Your Ref: OWPC25053
Our Ref: BR/233/19/PL 12-08-2019
Please ask for:
Mr S Davis

Part change of use of ground floor & formation of a first floor rear extension to create 2
No self-contained studio flats with associated refuse/ recycling & cycle store
(resubmission following BR/63/18/PL).

77 Aldwick Road Bognor Regis

Drawing
PROPOSED FLOOR PLANS

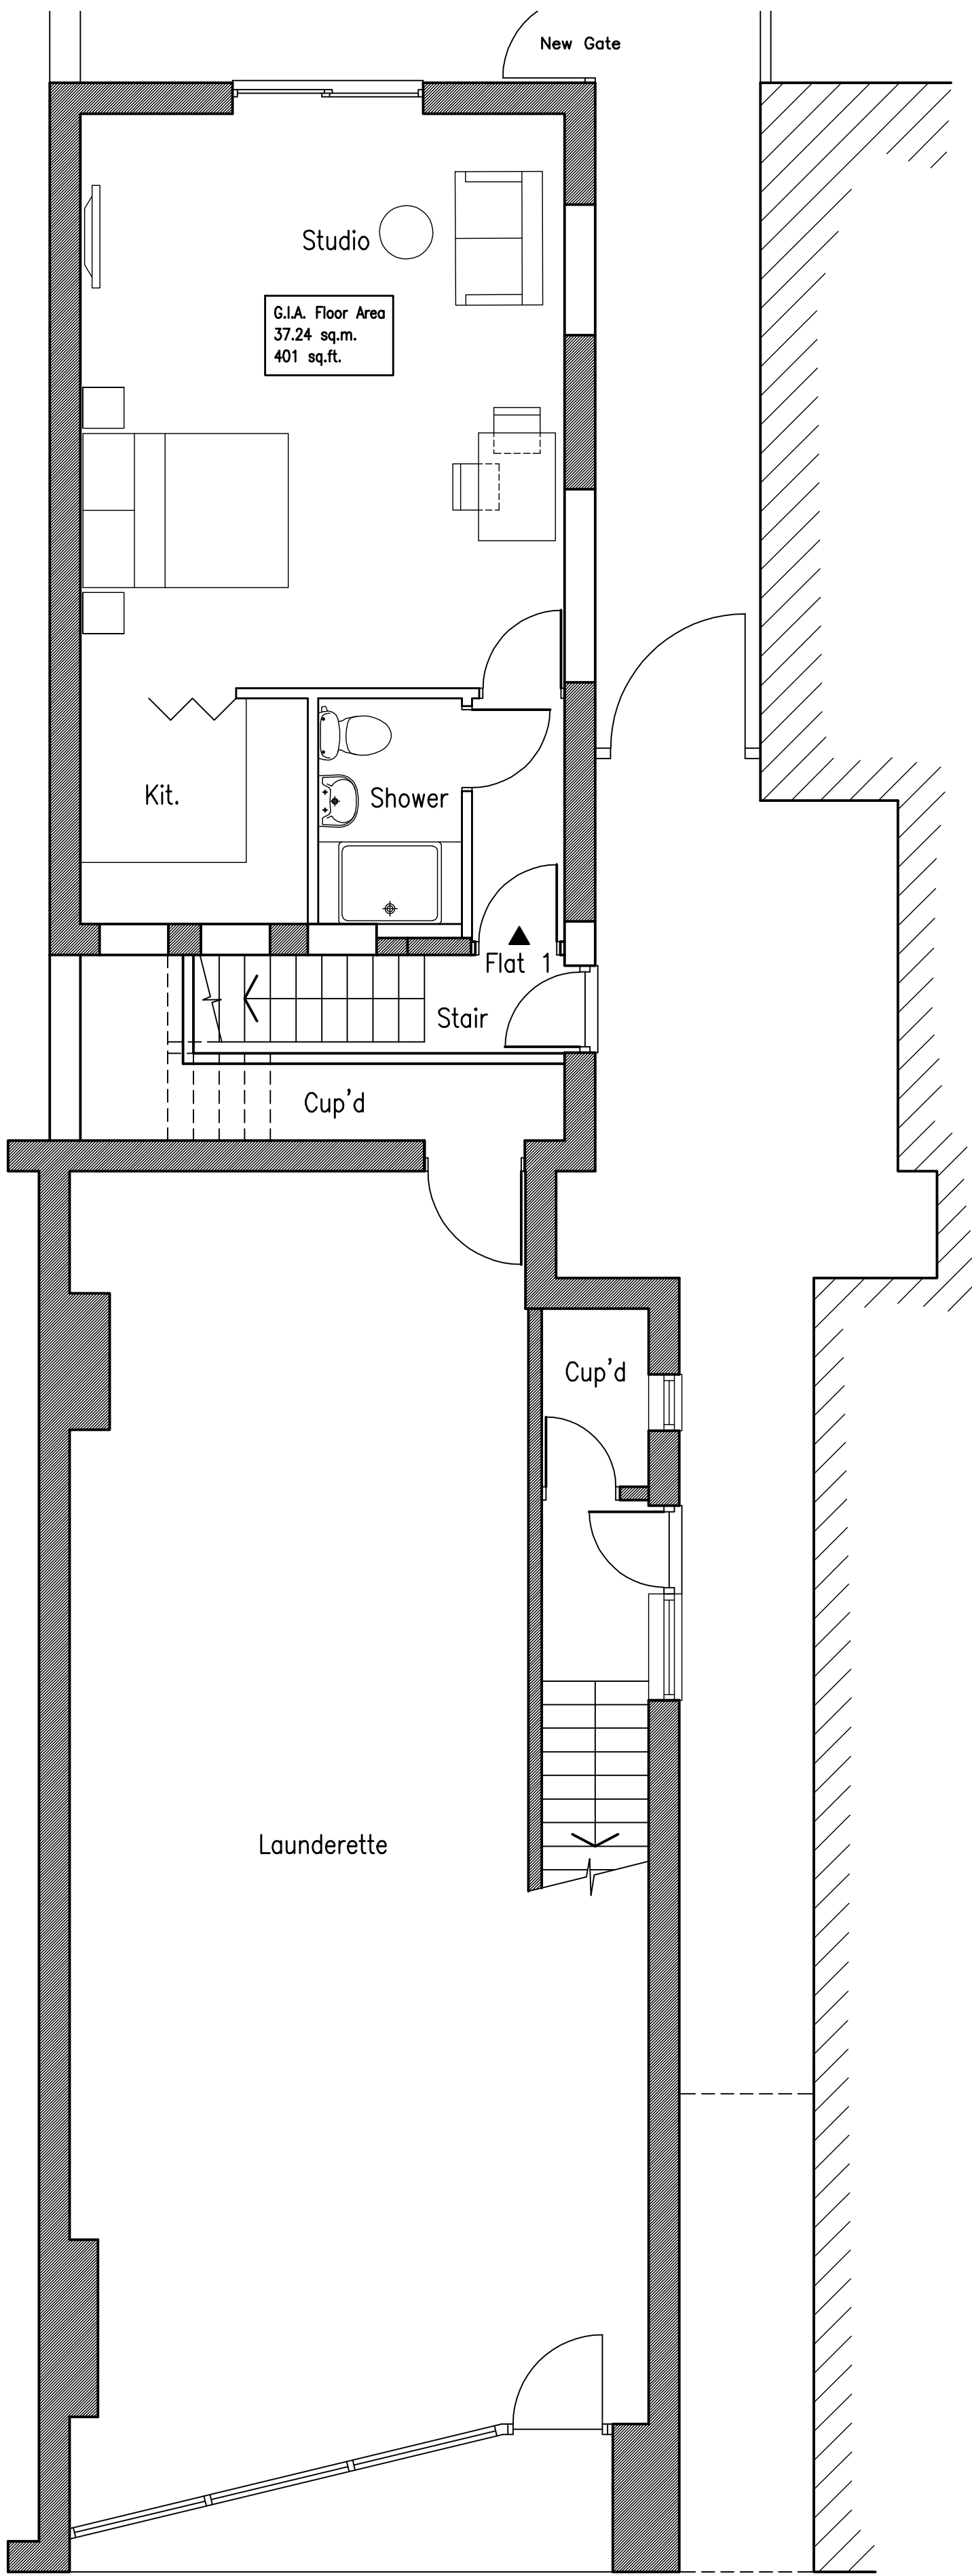
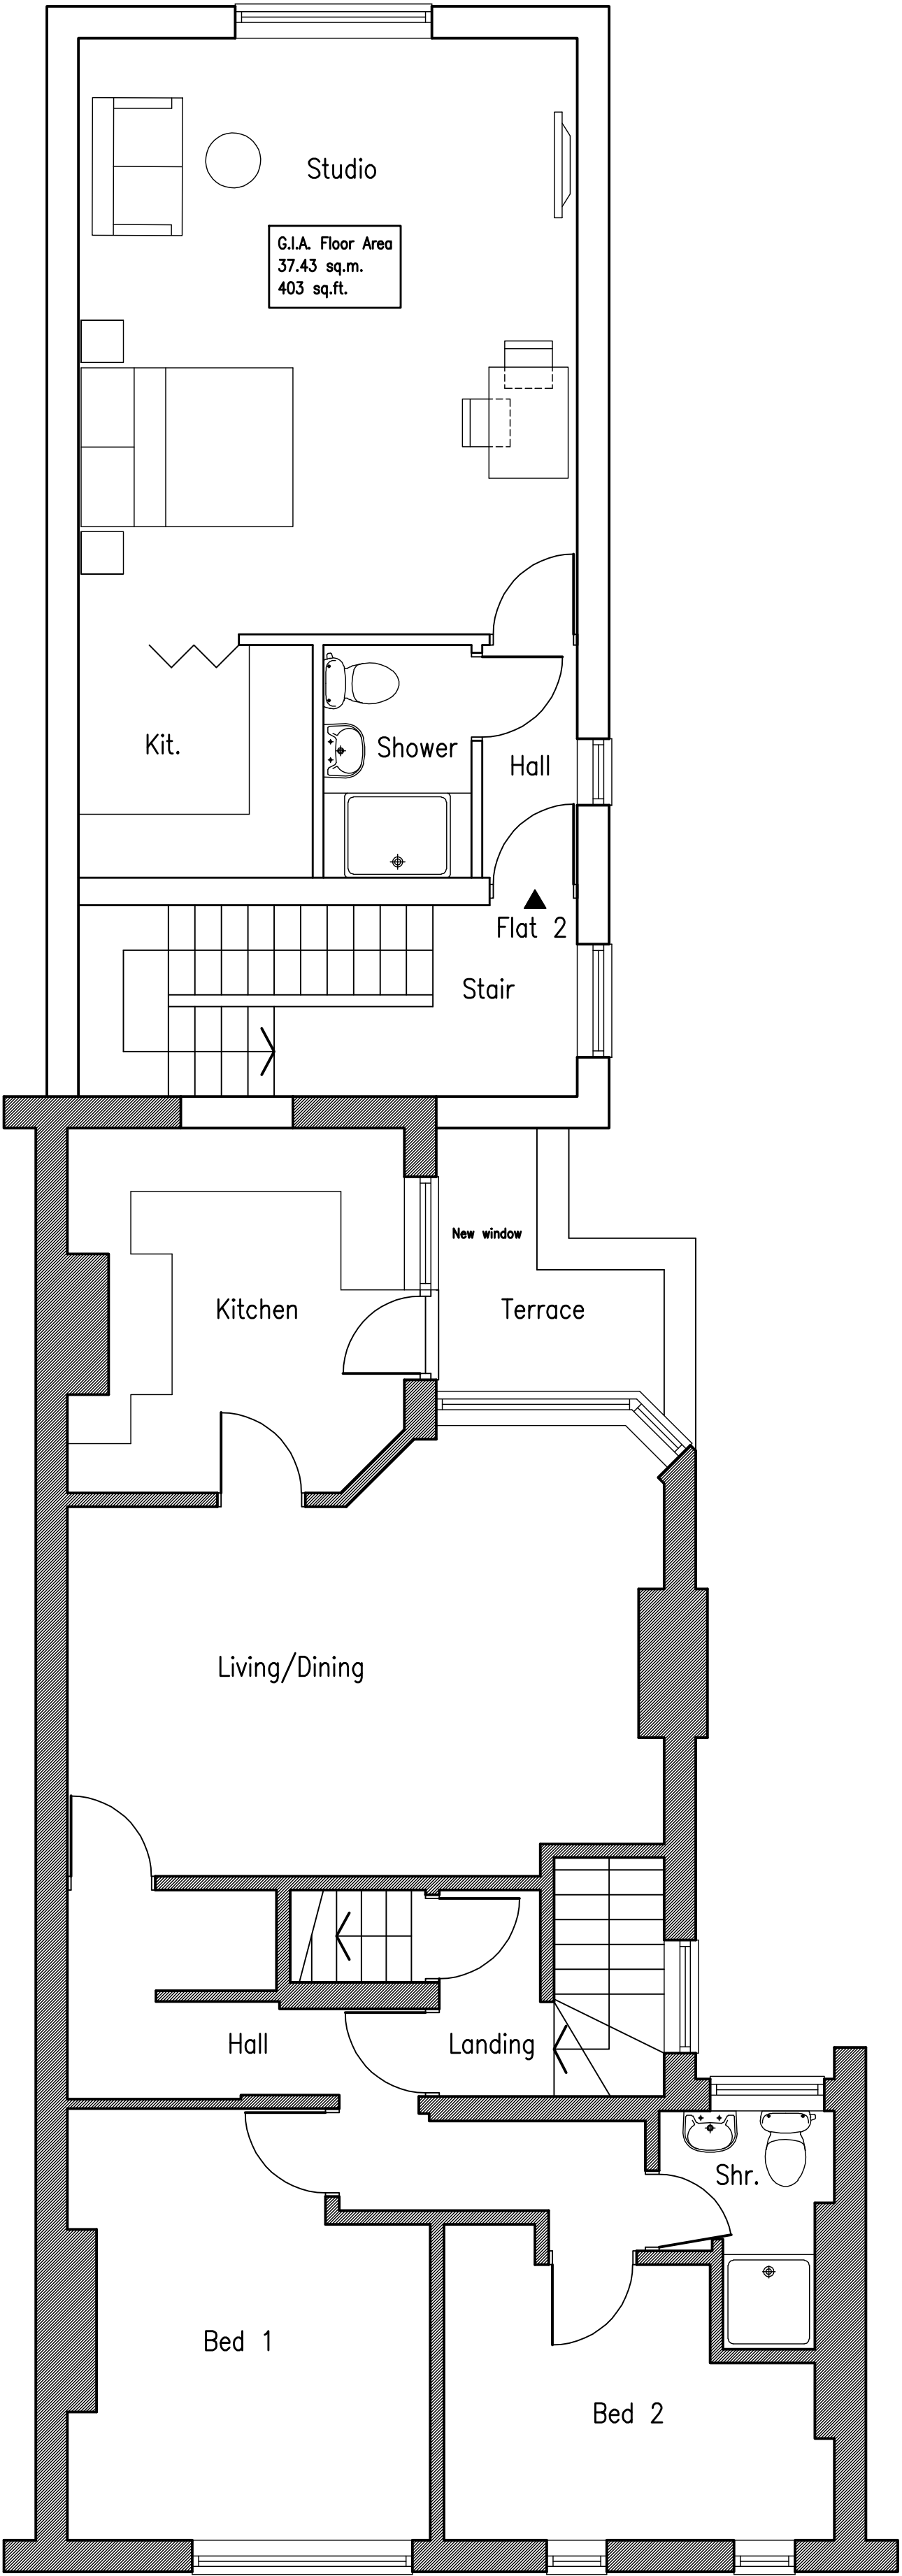
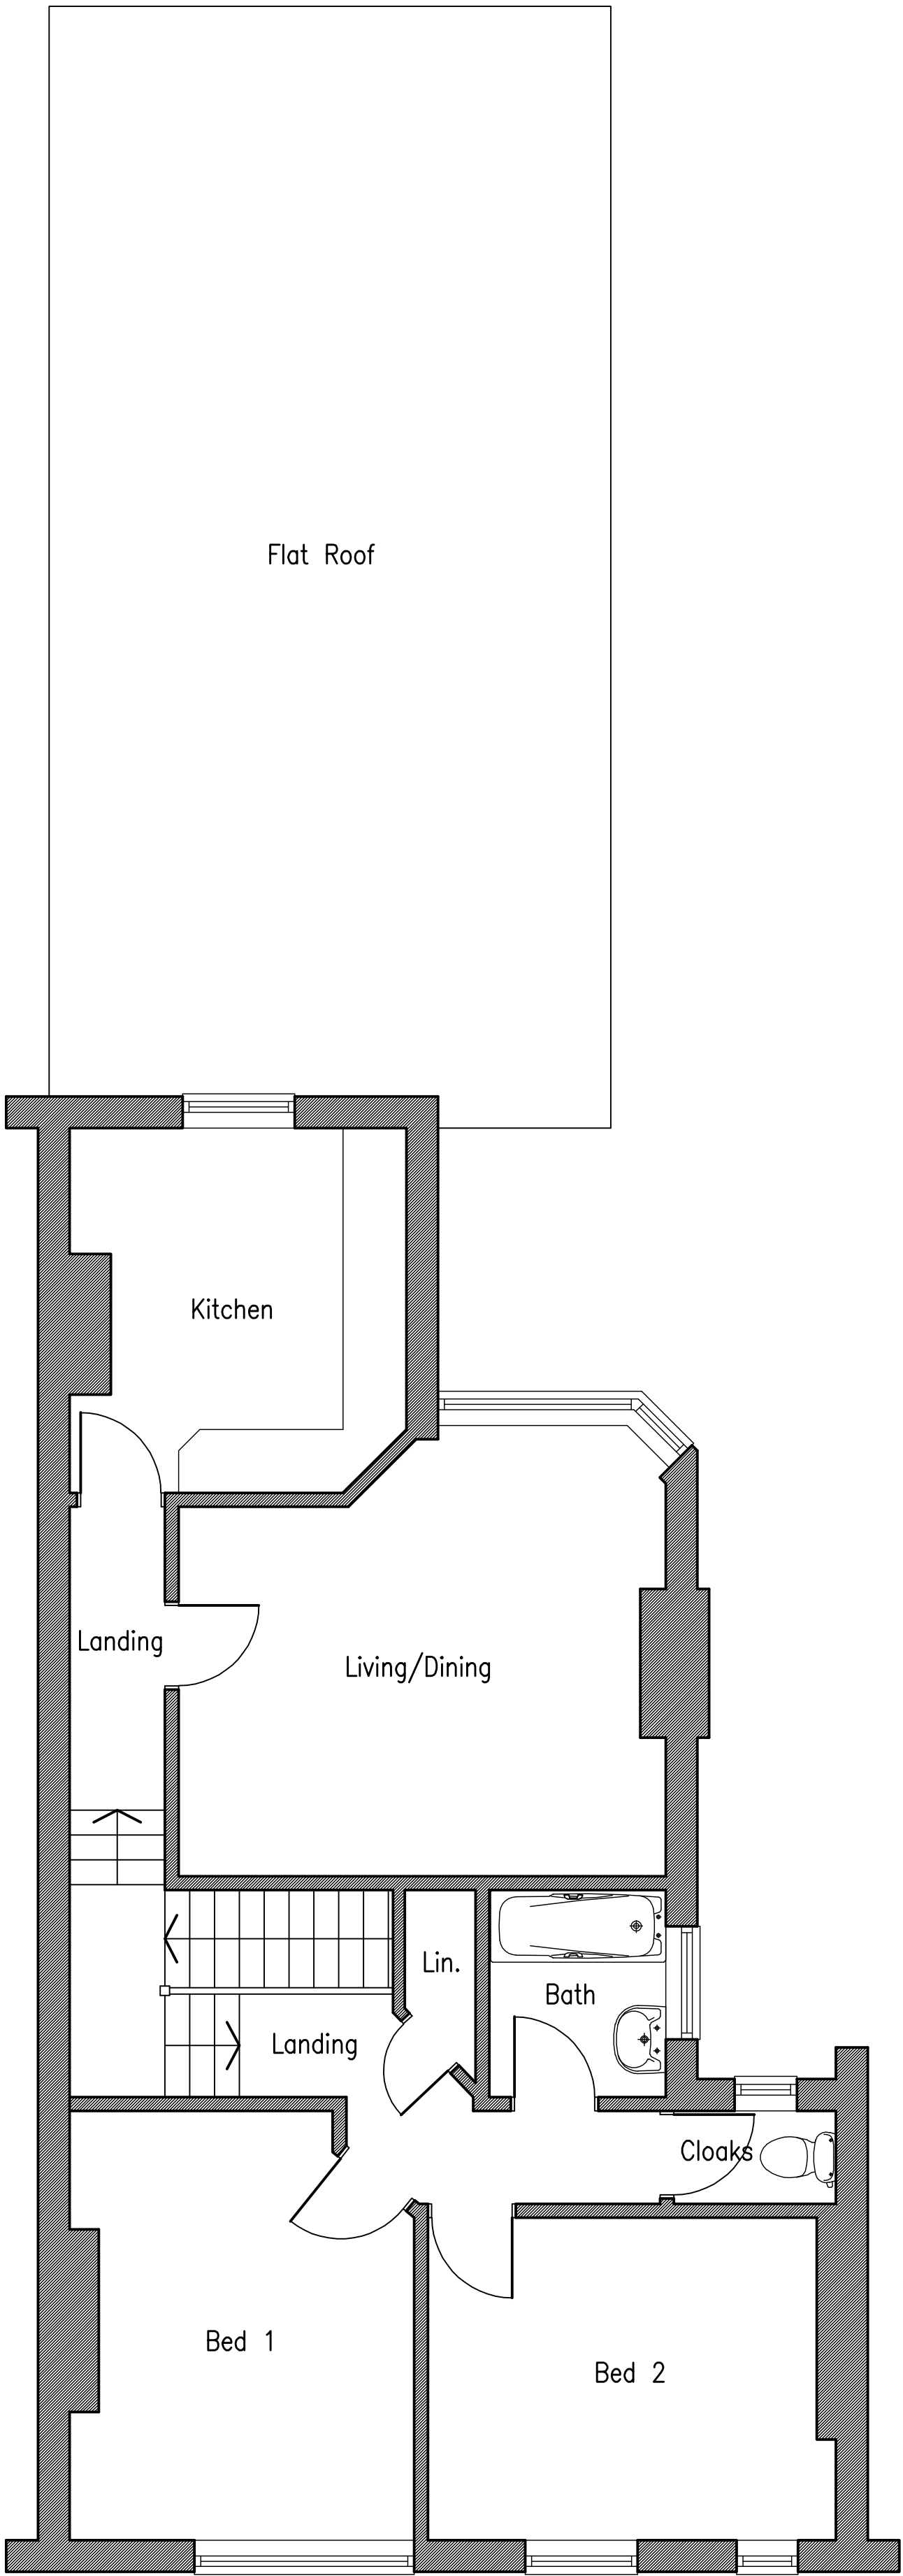
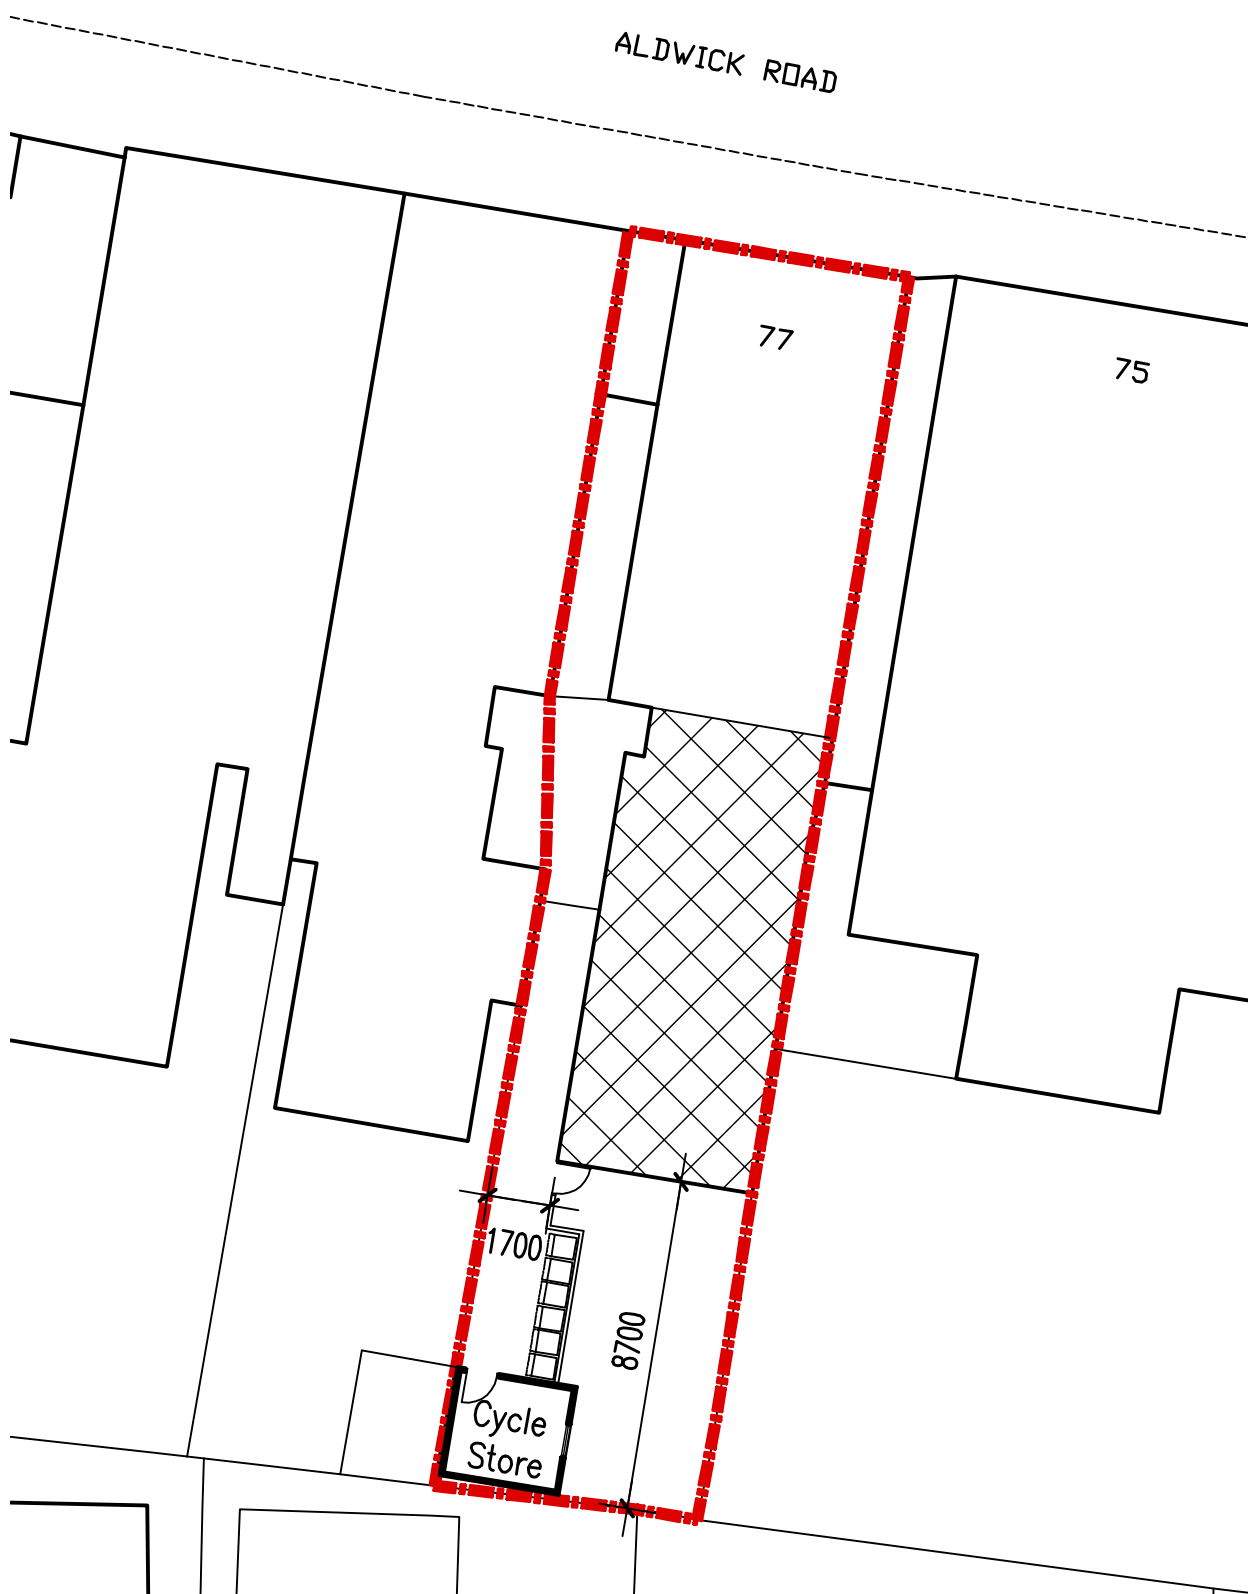
*The new first floor studio windows will overlook Nos. 10 & 14/16 Stocker Road resulting in
loss of privacy.*

*The new kitchen, hall and stair windows will face the windows of a neighbouring property,
resulting in a loss of privacy.*
